### **HyNet Carbon Dioxide Pipeline DCO**

Document Reference Number D.7.2

**THE HYNET CARBON DIOXIDE PIPELINE DEVELOPMENT CONSENT ORDER  
Planning Inspectorate Reference Number: EN070007  
NOTICE OF ACCEPTANCE OF AN APPLICATION  
FOR A DEVELOPMENT CONSENT ORDER BY THE PLANNING  
INSPECTORATE (ON BEHALF OF THE SECRETARY OF STATE FOR  
BUSINESS ENERGY AND INDUSTRIAL STRATEGY)**

DRAWING TITLE
**WORKS PLAN REGULATION 5(2)(i)
APPLICATION DOCUMENT
REFERENCE D.2.4
SHEET 19 OF 37**

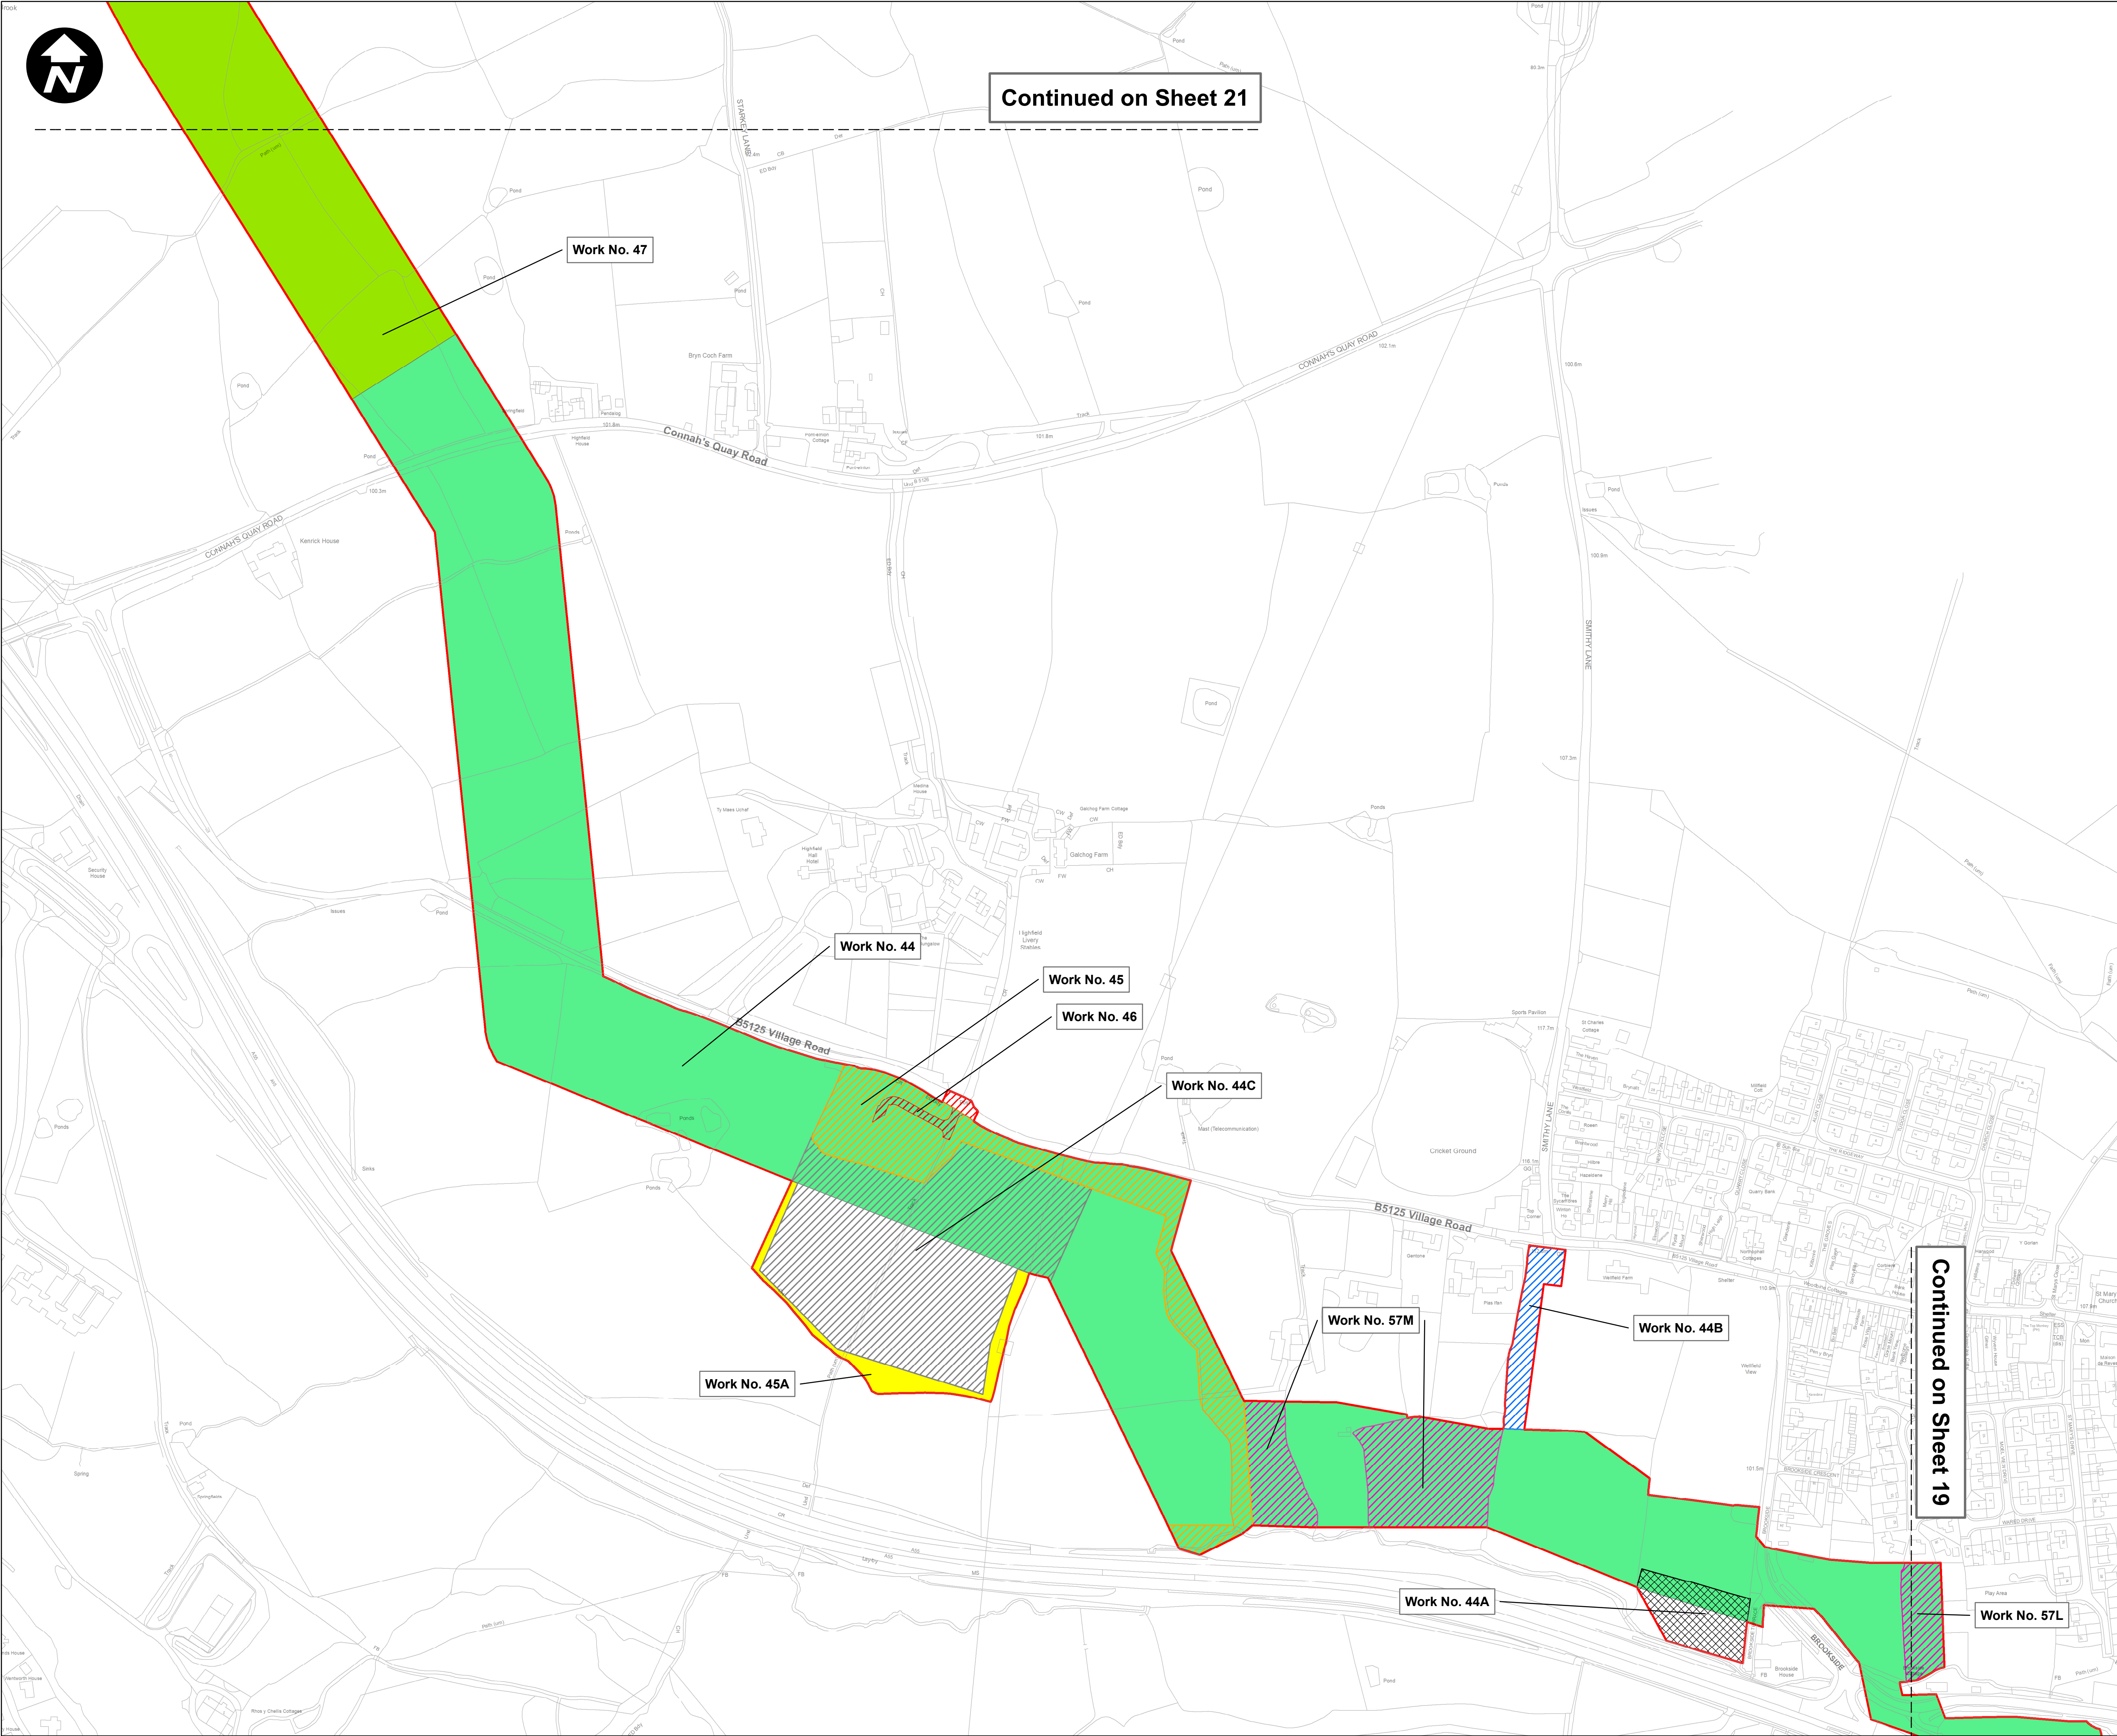
**SHEET 19 of 37** - WORKS PLAN REGULATION 5(2)(i) APPLICATION DOCUMENT REFERENCE D.2.4 Specific area: Works No. 57K, 43B, 43A and 57J [Identified as Alltami Brook: Section 5.0 of the CMRA]

Our records indicate that there are six mine entries (three on-site mine adits CA ref: 327367-053, 327367-048 and 327367-049) and three off-site adits CA ref: 327366-235, 327366-235 and 327367-234); recorded shallow coal mining; and a coal seam of workable thickness outcrops at or close to the site that may also have been worked at shallow depths. These mining features are present within the area to the west and east of Pinfold Lane and north of Magazine Lane, Ewloe.

The CMRA identifies the two mine adits and comments that a geophysics survey was carried out to confirm the presence of these features. The report author states that no indication of the mine adits were found, although a potential void was located in the north eastern corner of the field. However it is noted that due to sight constraints, a full survey was not completed.

DRAWING NUMBER
EN070007-D.2.4-WP-Sheet 36

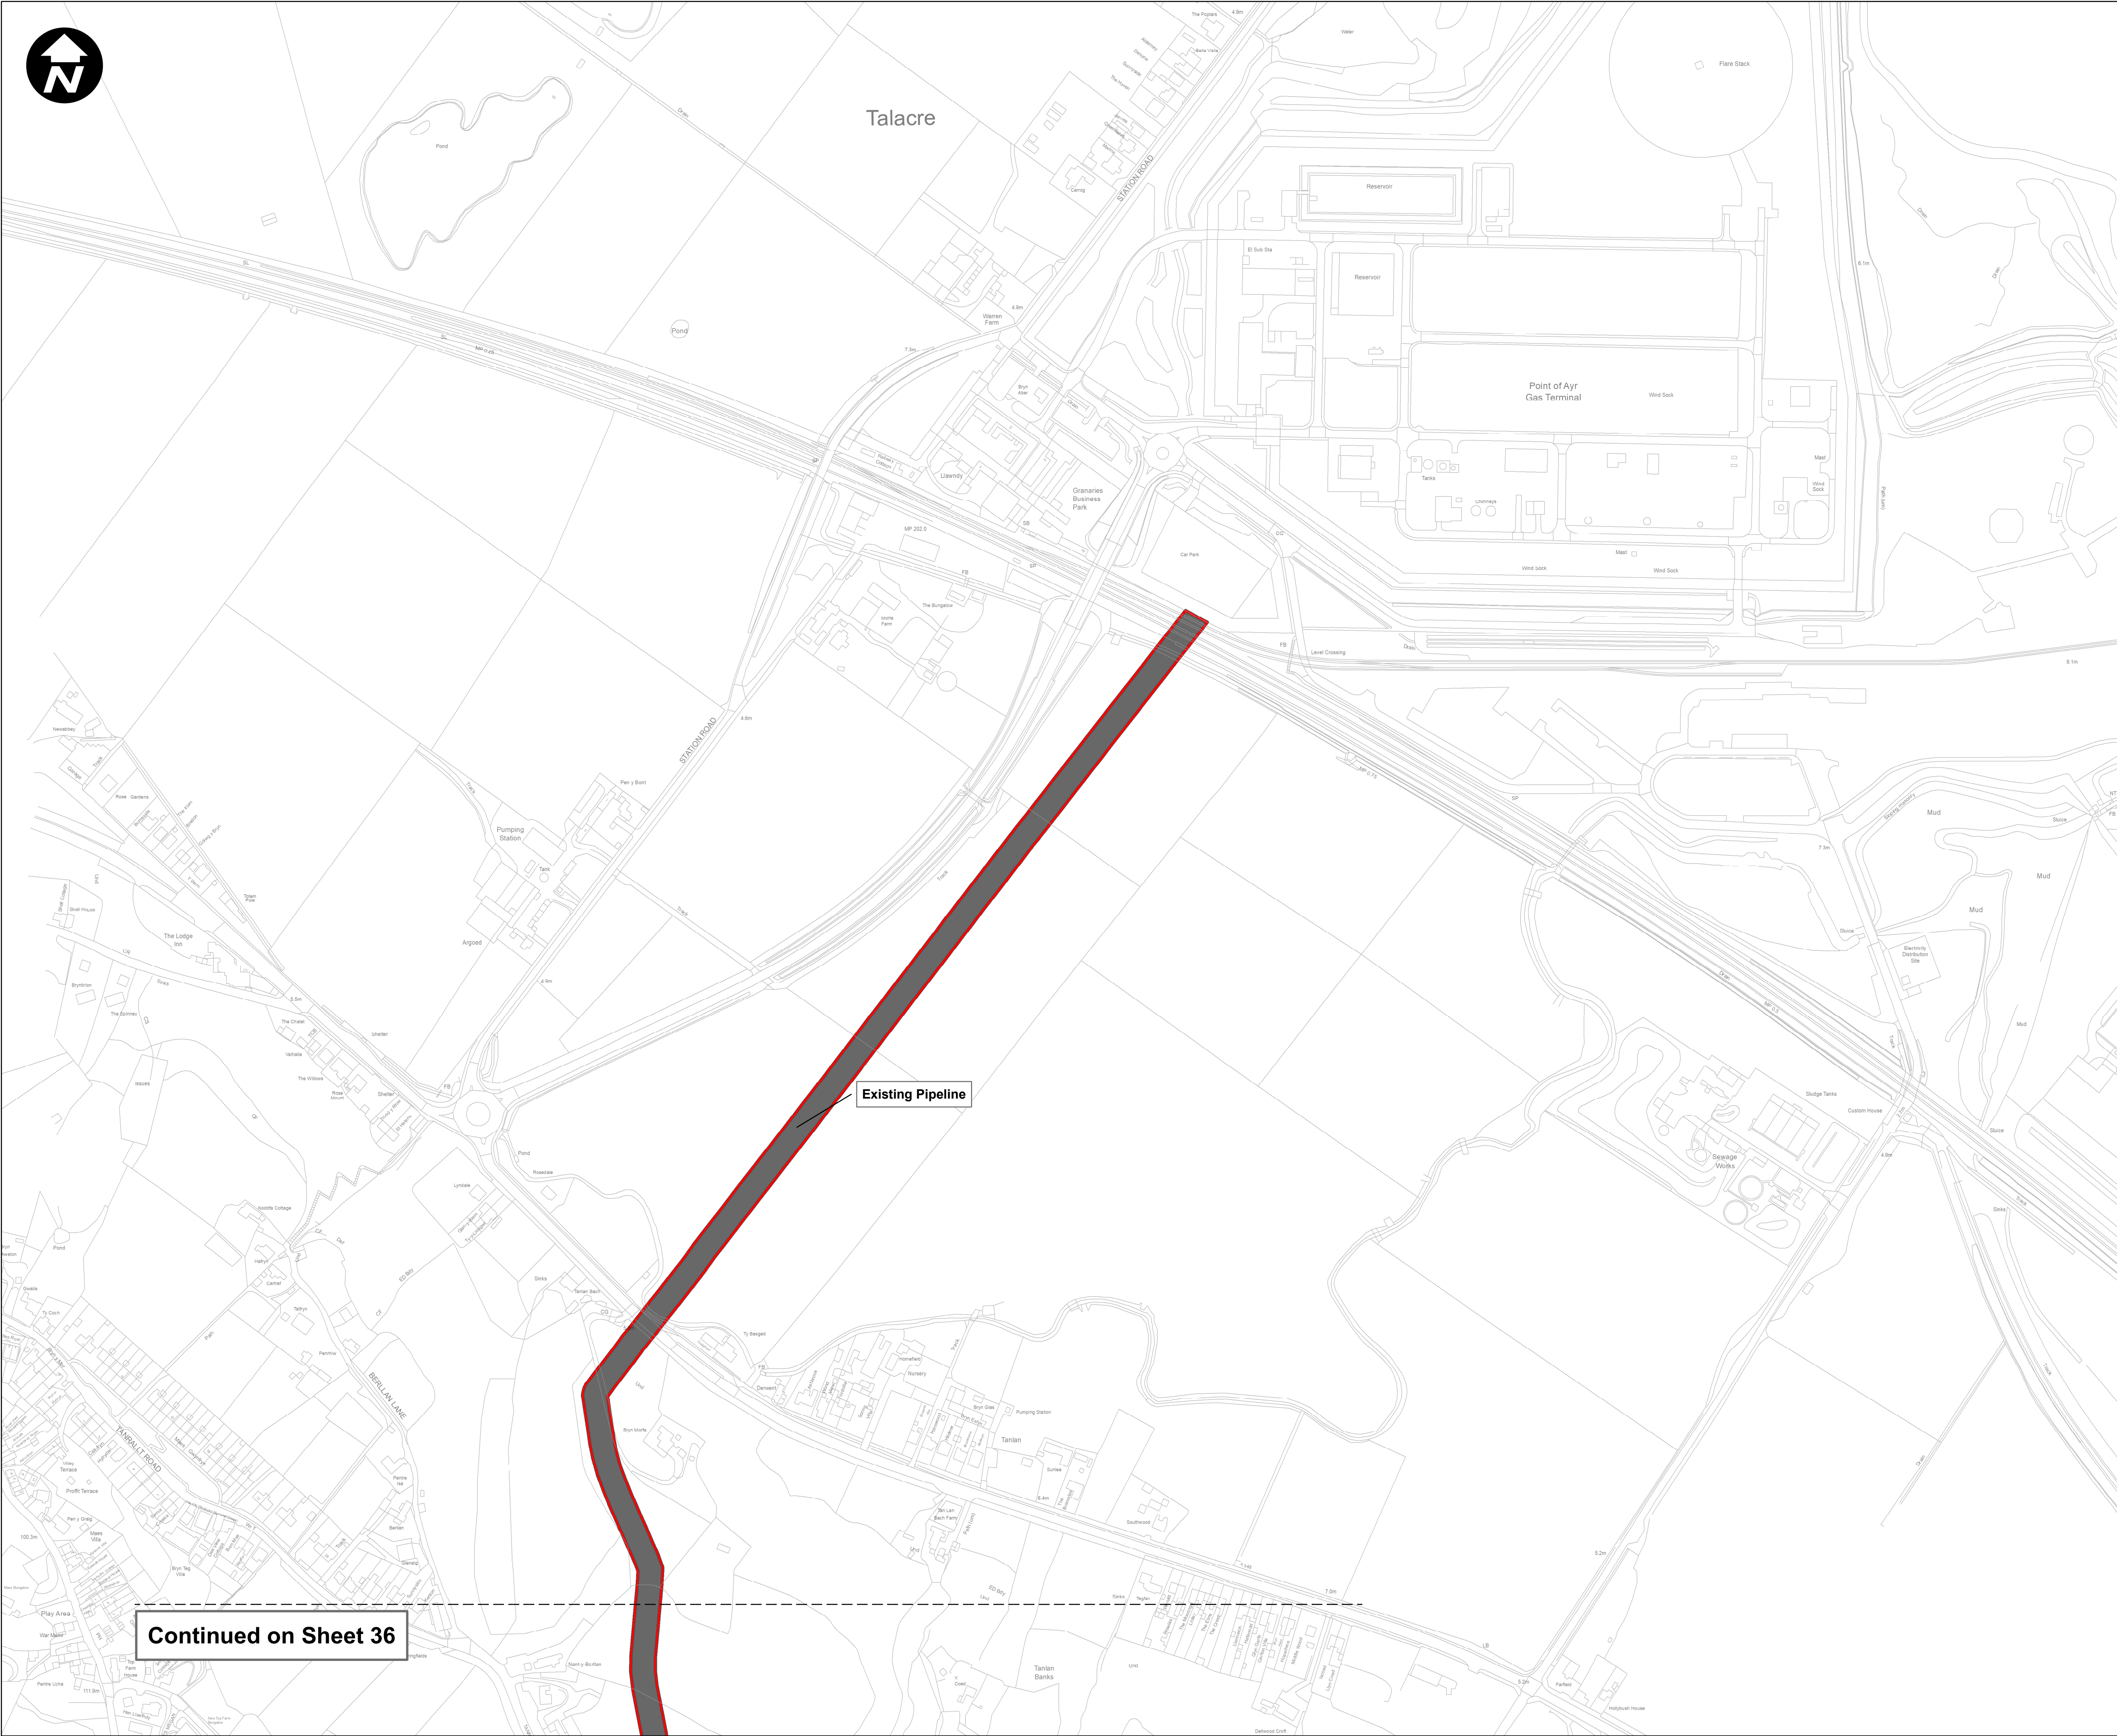
**SHEET 36 and 37 of 37** - WORKS PLAN REGULATION 5(2)(i) APPLICATION DOCUMENT REFERENCE D.2.4 Specific area: Existing Pipeline[Identified as Point of Ayr Section 4.2 of the CMRA]

Our records indicate that the zone of influence of a recorded mine entry (CA shaft ref: 311382-011) extends into the red line boundary and the site lies within an area of probable shallow coal mine workings.
